**Application by Aquind Limited for an Order Granting Development Consent for the
Aquind Interconnector (Ref. EN020022)**

**TRANSCRIPT OF SUBMISSIONS TO OPEN FLOOR HEARING – OFH 1
PORTSMOUTH CITY COUNCIL
30 NOVEMBER 2020**

Compulsory Aquisition Hearing 1 – Appendix 1
- Exhibit 15 Cross-section showing the typical
arrangement of the construction corridor
across Milton Common

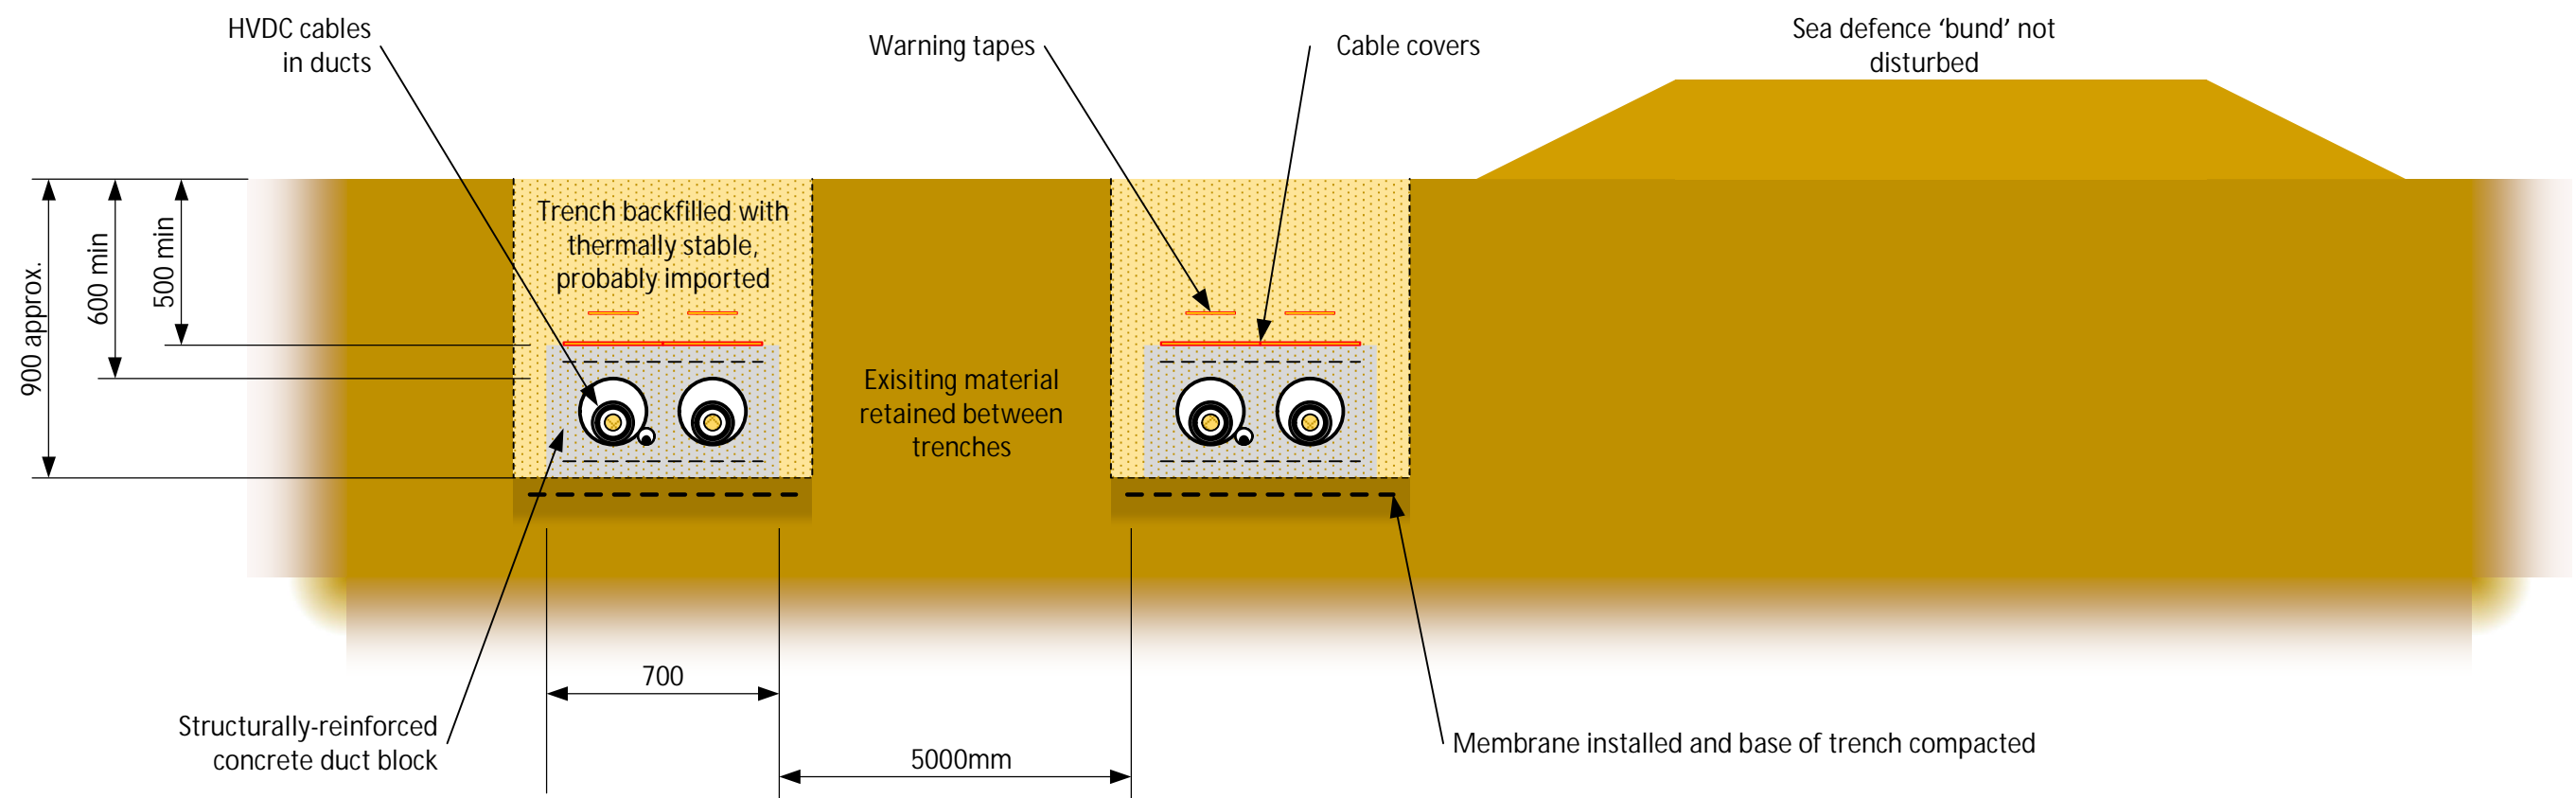
71. Across Milton Common, it is anticipated that the cable will progress through the corridor adjacent to the path which runs from north-to-south through the Common, parts of which form the coastal flood defences. At the northern part of the coastal defences, a short HDD will be required below the bund of the coastal defences. The cable would then continue south, adjacent to the path to the south-east corner of Milton Common. This suggests that only the crossing of the secondary defence will be HDD and the remainder of the route across the common will be open trenched.
